15 January 2014 (Rev. 16 January 2014)

RE: Press Hotel – 119 Exchange St., Portland, Maine

Following are responses to comments contained within the review from FirePro dated December 9th, 2013:

A4.03

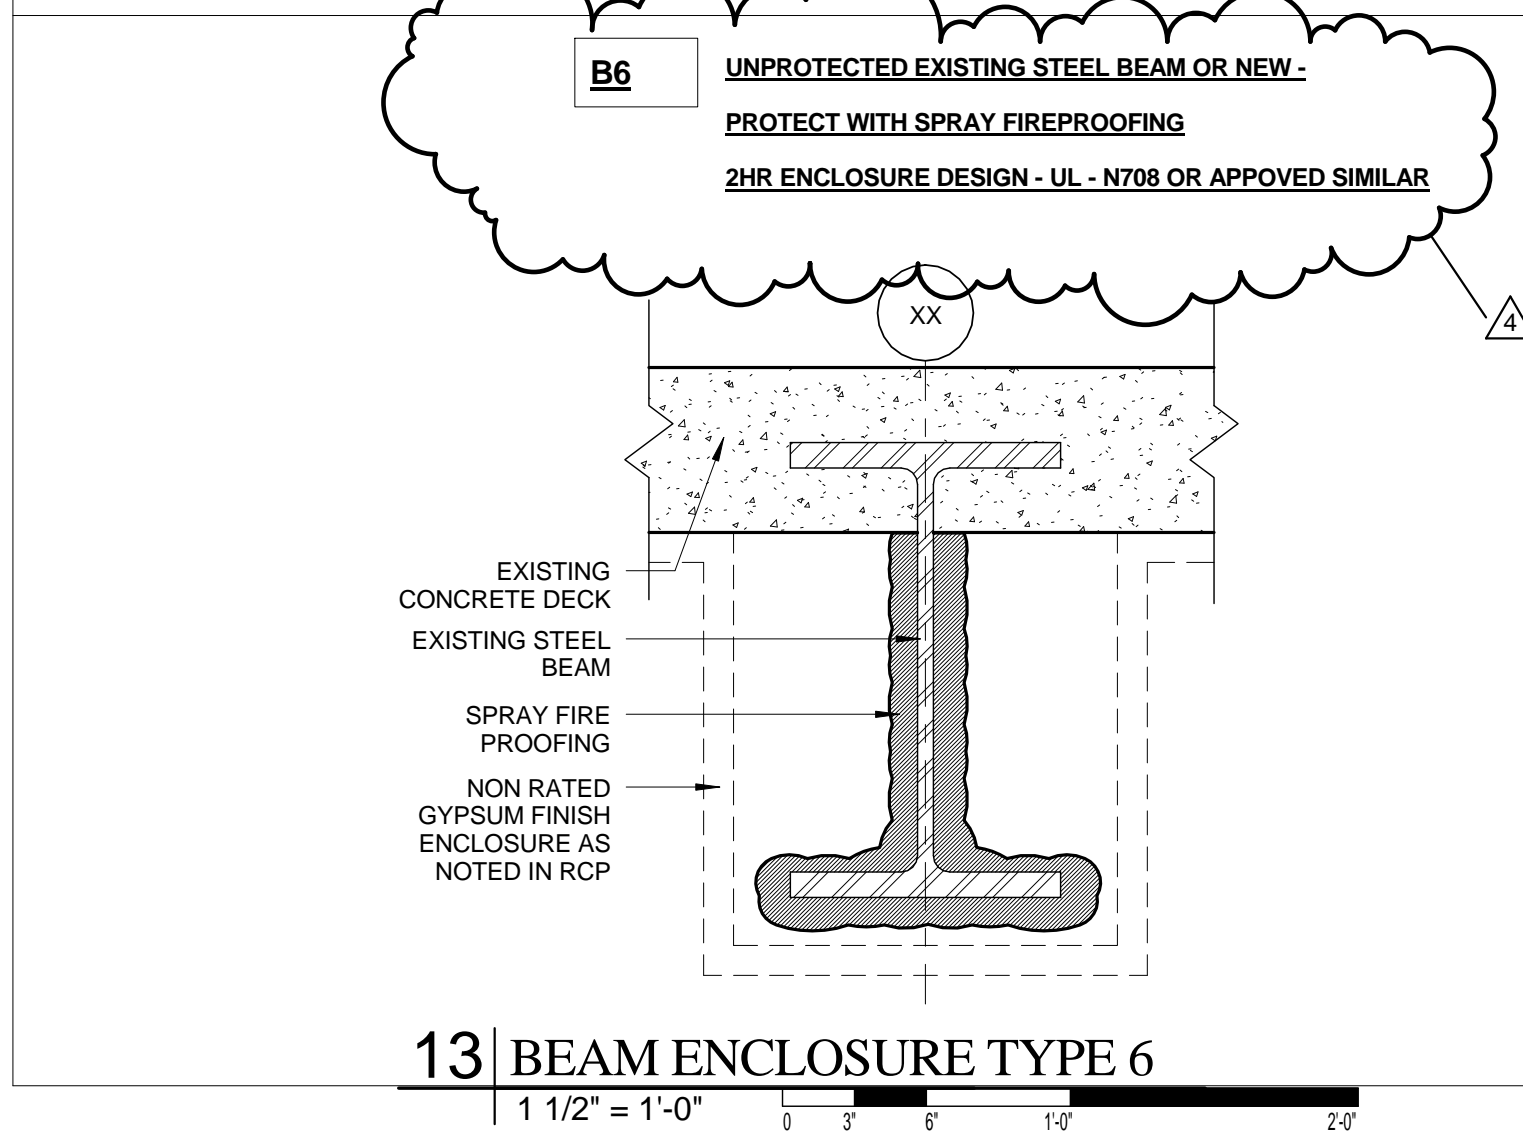
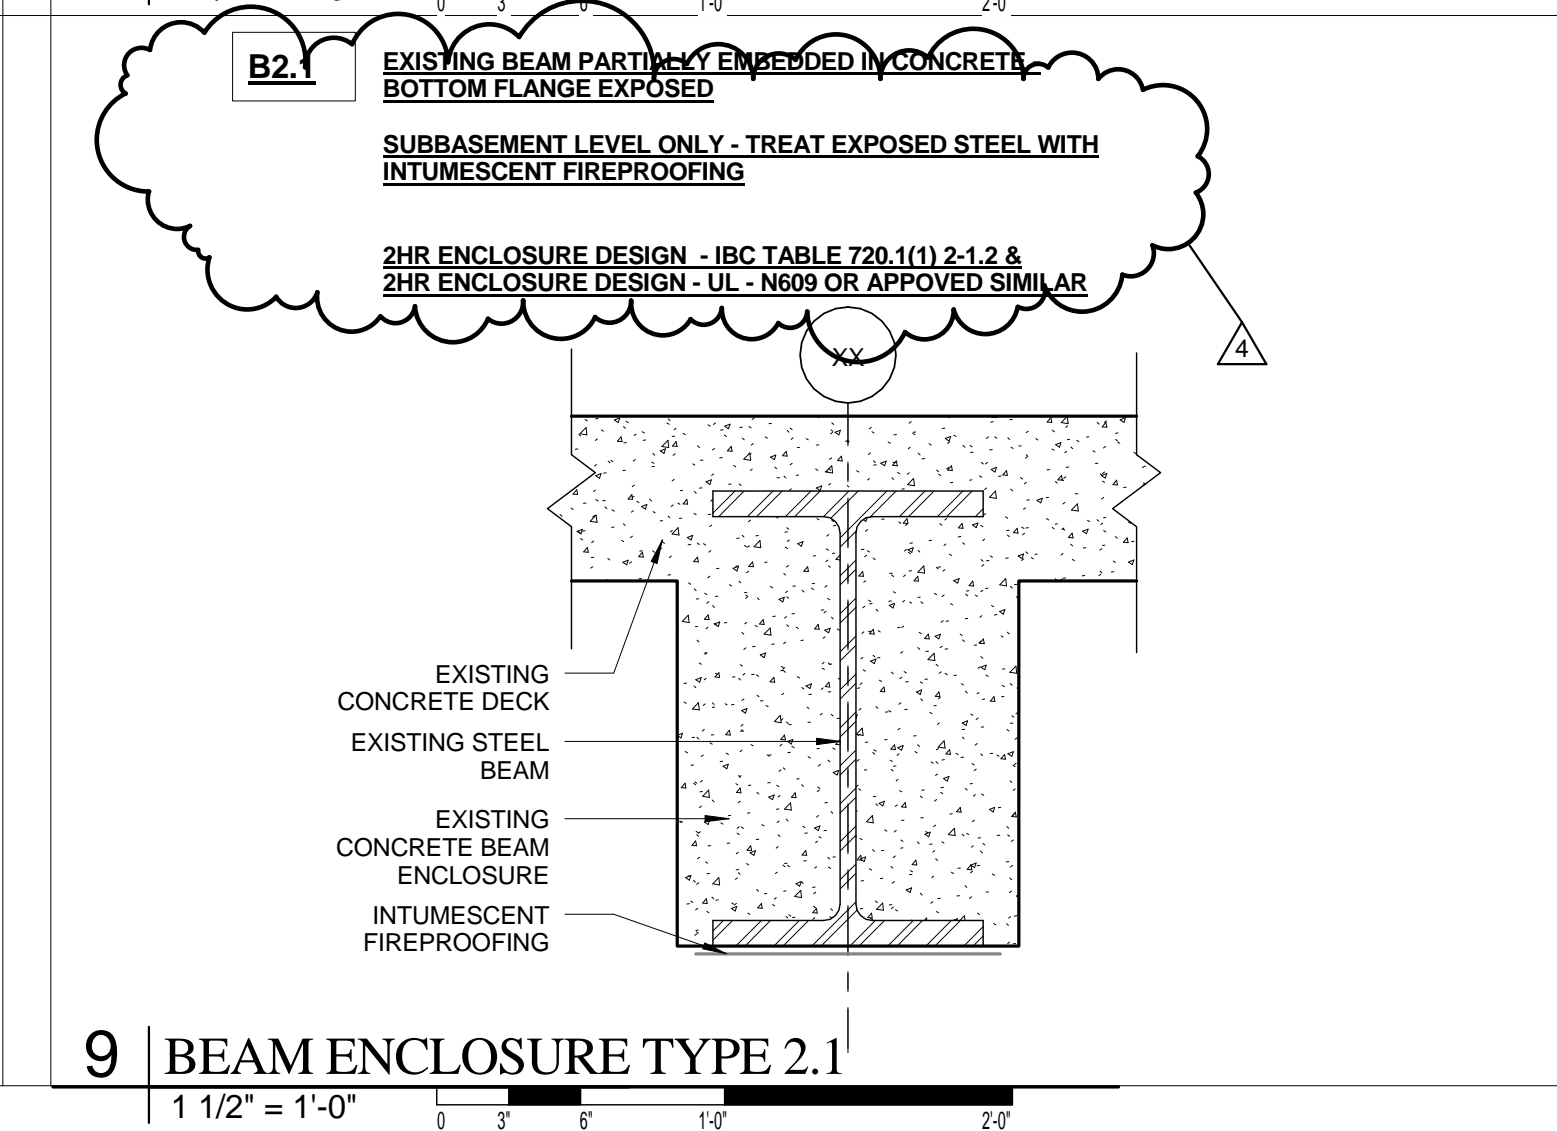
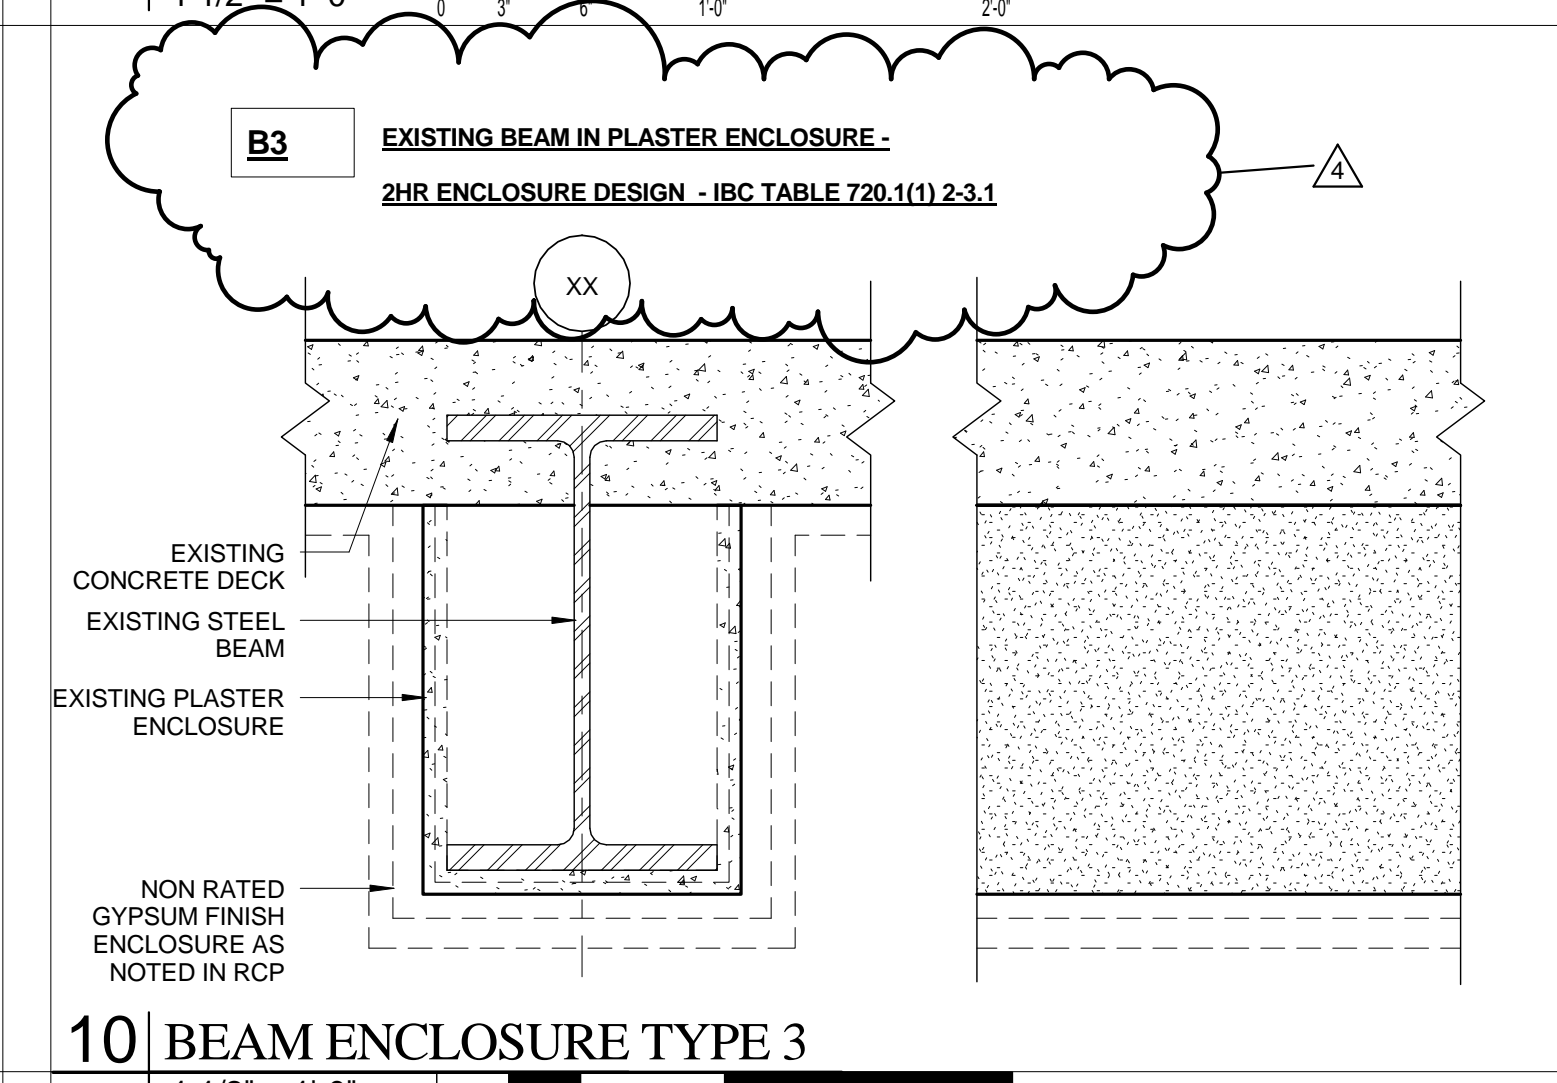
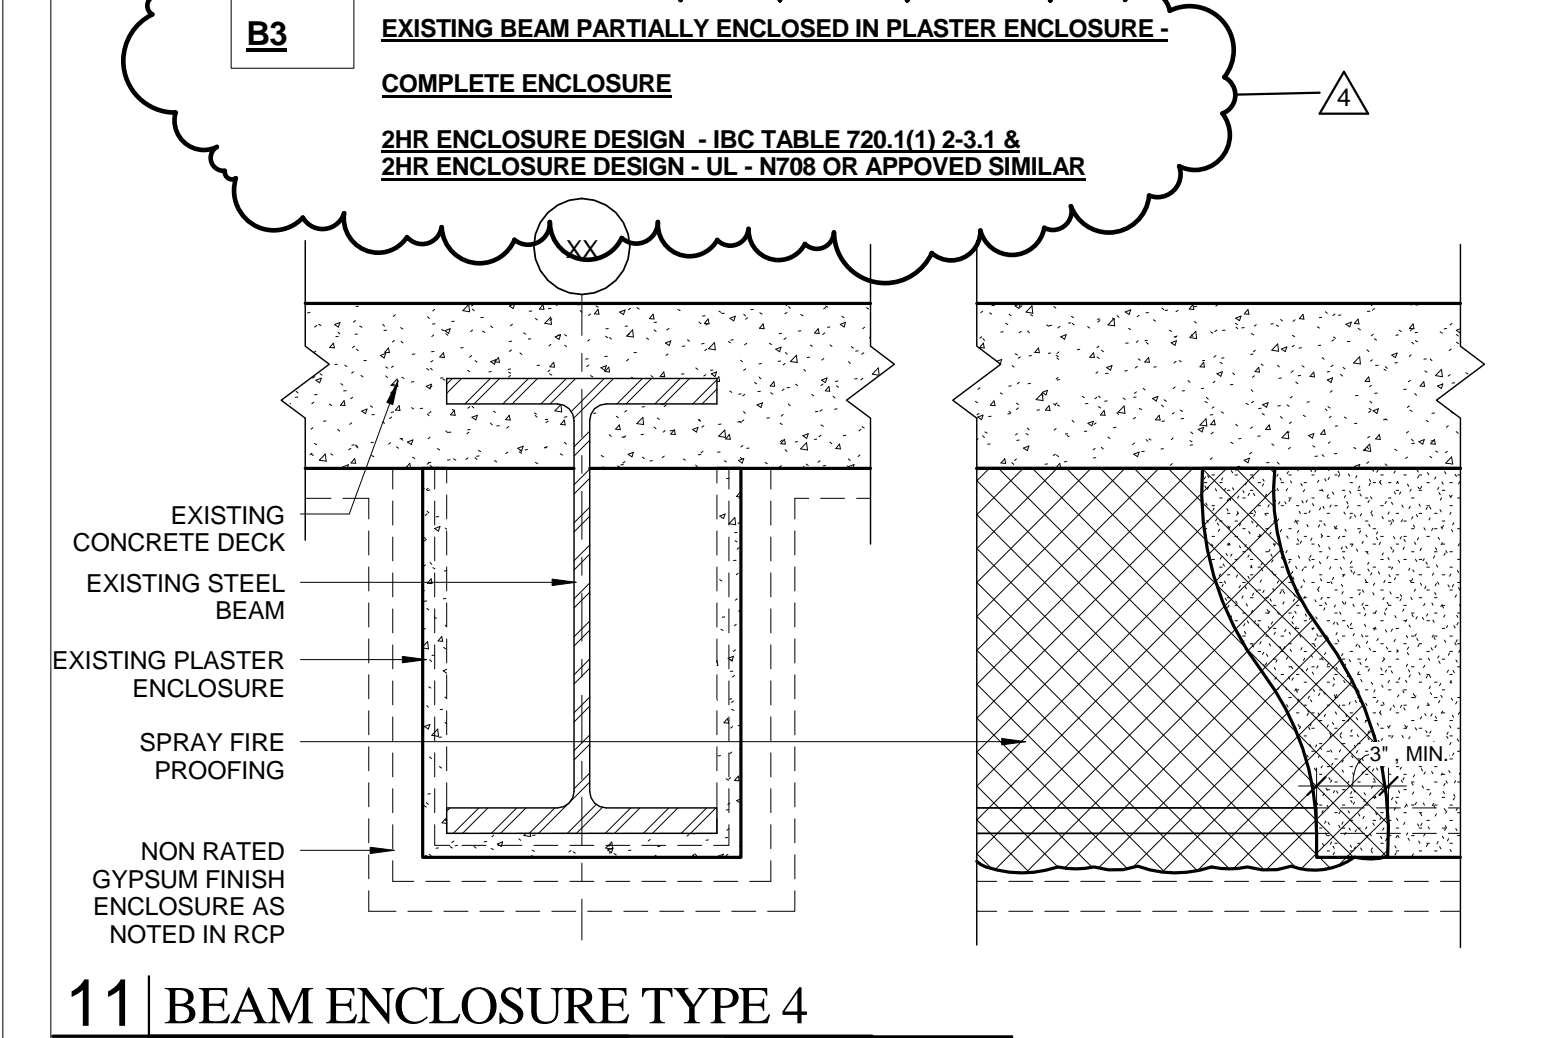
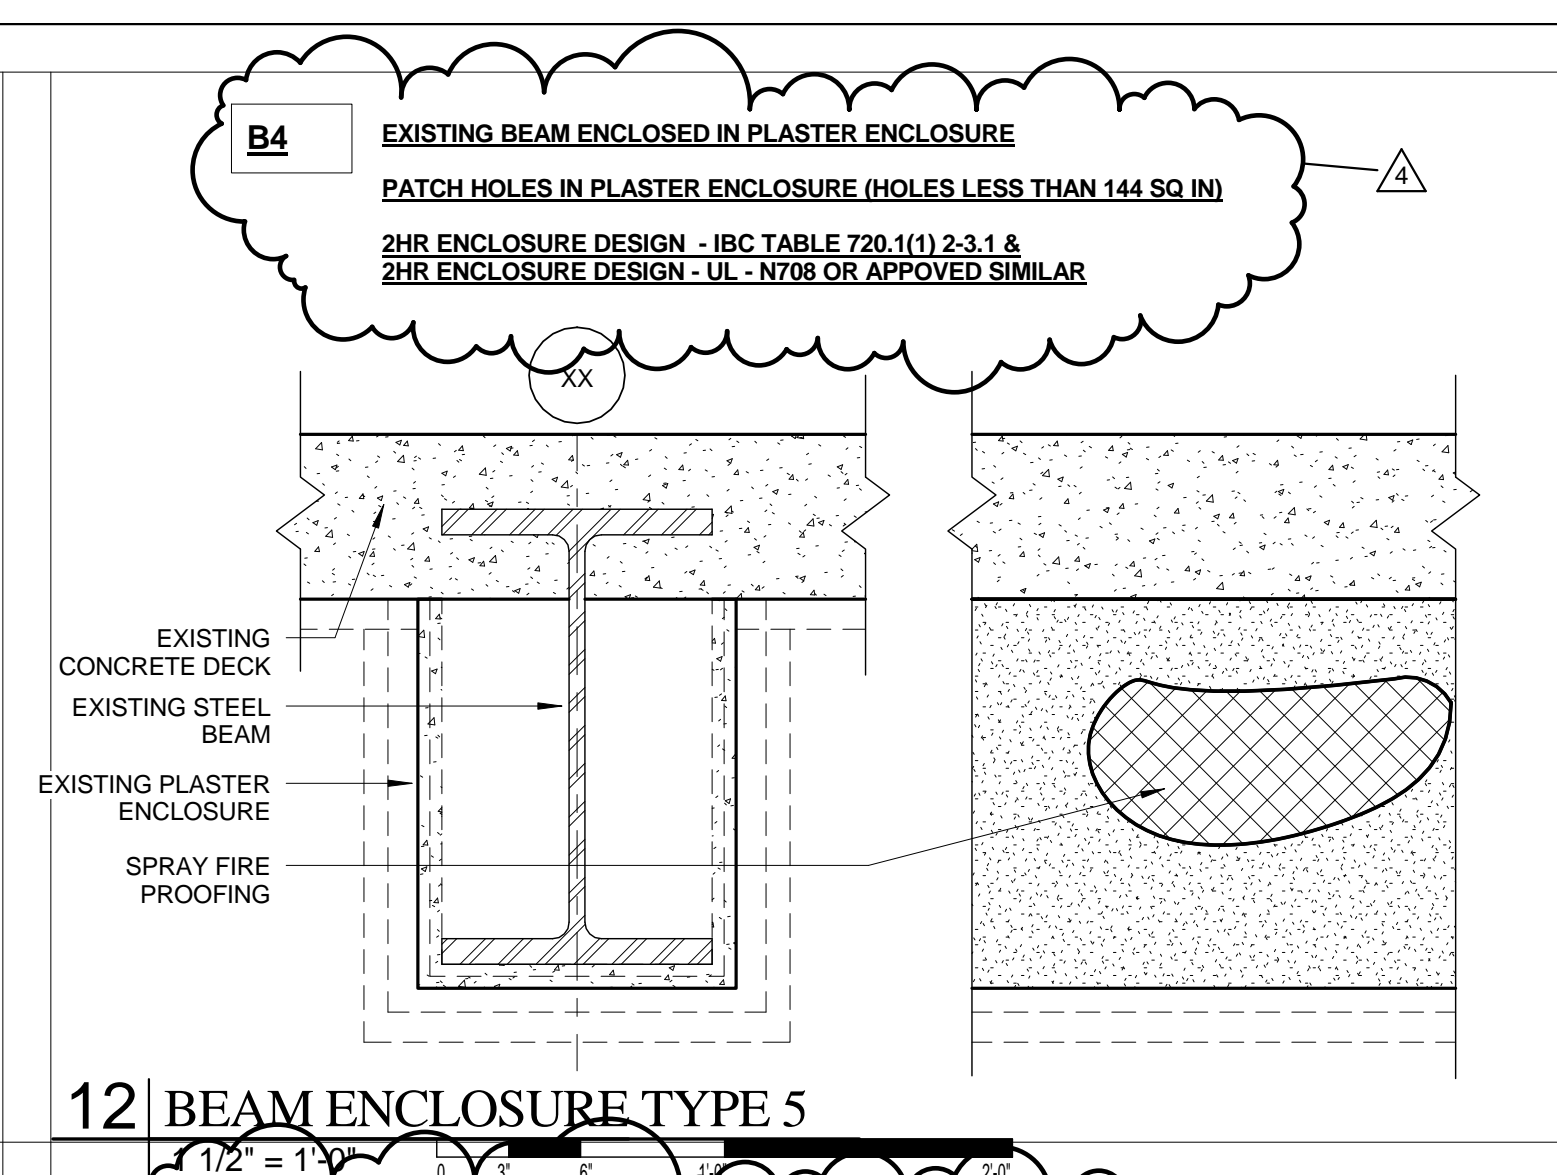
2. *Calculations for the existing plaster and concrete structural fire proofing. Response: See revised rating designations on each detail on Revised Sheet A4.03, included under separate cover. The ratings and UL assemblies for each condition have been provided.*
